From: Jeff Tarling
To: Errico Thomas; Jean Fraser
CC: Barbara Barhydt; Caitlin Cameron; David Margolis-Pineo
Date: 7/2/2015 4:09 PM
Subject: Re: Fwd: 2970 Bangor Savings - Marginal Way
Attachments: Beachgrass.JPG; BGisland.JPG

The proposed 2970 Bangor Savings Bank landscape plan for Marginal Way is acceptable with the condition that ONE tree is planted in the rear right side traffic island and vegetation is added to the proposed rear curbing area.

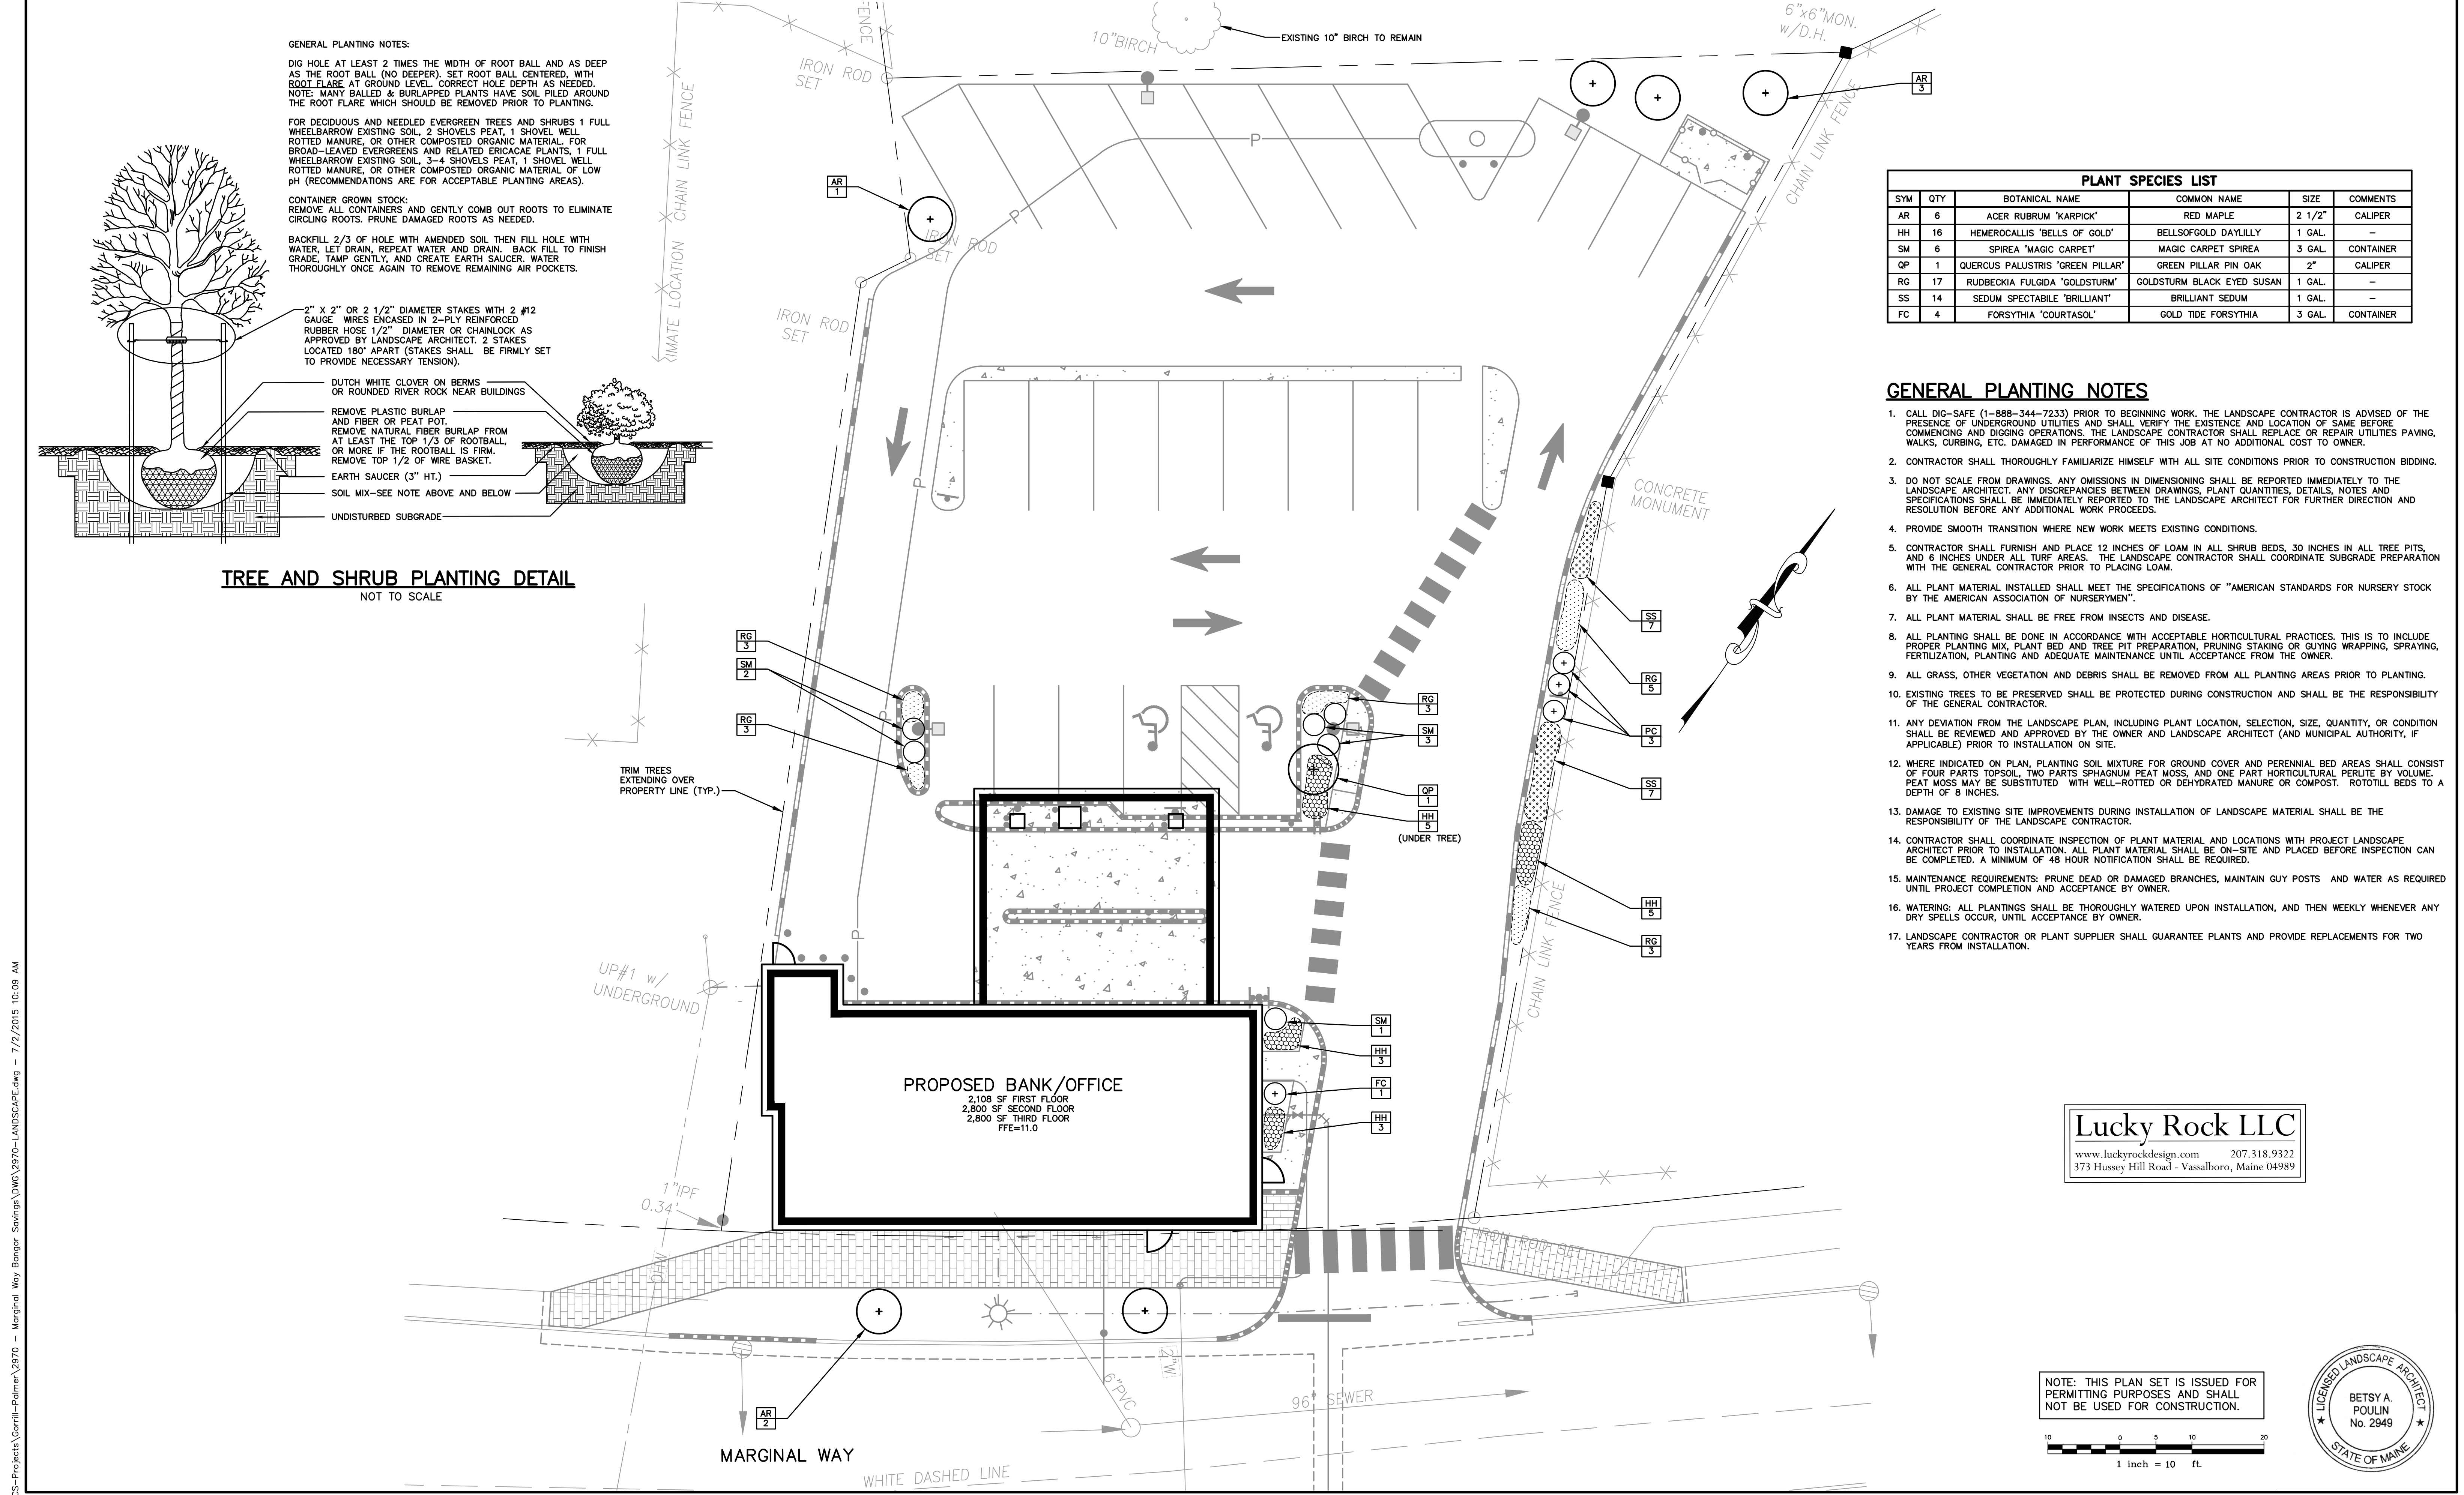
The attached photos demonstrate that ornamental grasses can grow in restricted spaces, this is an MDOT project called Hags Parkway / Route One in Scarborough where they successfully use beach grass in a high salt area with good results. The overall Bangor Savings Bank project has much less than average landscape percentage due to lot orientation and circulation patterns, however a simple planting of low maintenance beach grass would work, thus is a recommended condition of approval.
